**Shoalhaven Starches – MP06_0228 Mod 23 – Gas Fired Co-generation Plant – EPA
Comments**

Thank you for the request for advice, requesting the review by the NSW Environment Protection Authority (EPA) of the Statement of Environmental Effects (SEE) for the proposed modification (MP06_0228-Mod-23) at 160 Bolong Road, Bomaderry.

- *Statement of Environmental Effects – Proposed Modification to Approved Gas Fired Co-generation Plant* – Cowman Stoddart Pty Ltd – 2 September 2021
- *Environmental Noise Impact Assessment Shoalhaven Starches – Proposed Modification to Shoalhaven Starches Expansion Project 06_0228 – Proposed Modification to Approved Cogeneration Plant – Modification 23* – Harwood Acoustics Acoustical Consulting – 19 August 2021
- *Shoalhaven Starches Modification 23 – Air Quality Assessment* – GHD Pty Ltd – 1 September 2021

Table 8.7 Summary of highest measured and predicted $PM_{2.5}$ levels, $\mu g/m^3$ (at receptor C6)

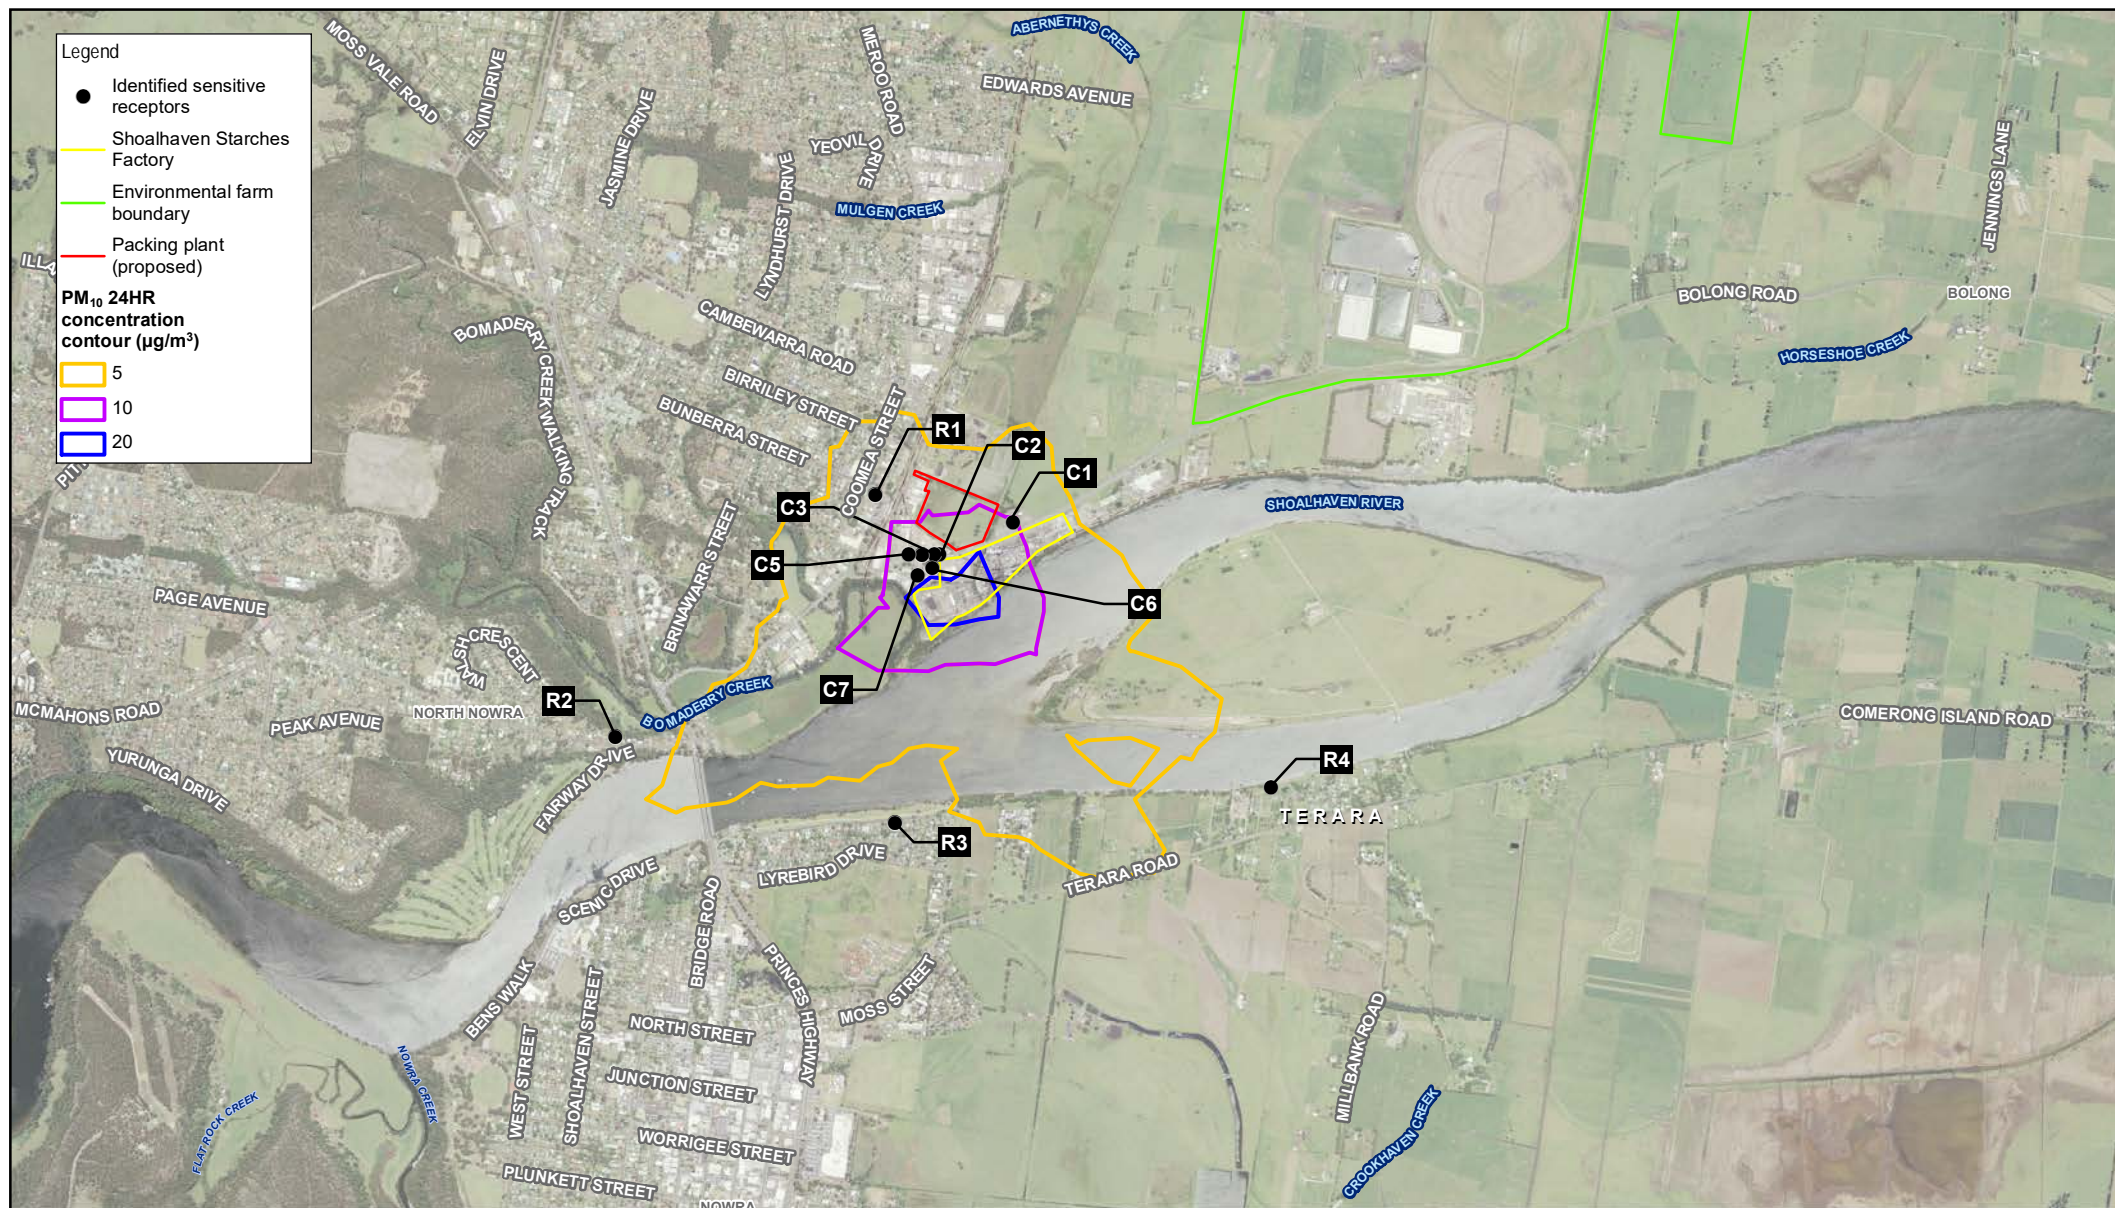
h. Assessment predicts exceedances of 24-hour PM₁₀ and 24-hour PM_{2.5}

The AQIA predicts 3 additional exceedances of PM₁₀ (24 hour) and PM_{2.5} (24 hour) at commercial receptor C6. The AQIA does not provide further analysis on the predicted exceedances, including but not limited to source contribution analysis, and identification of additional mitigation measures.

The EPA recommends the proponent revise the AQIA to include additional analysis of the predicted exceedances and identification of additional mitigation measures.
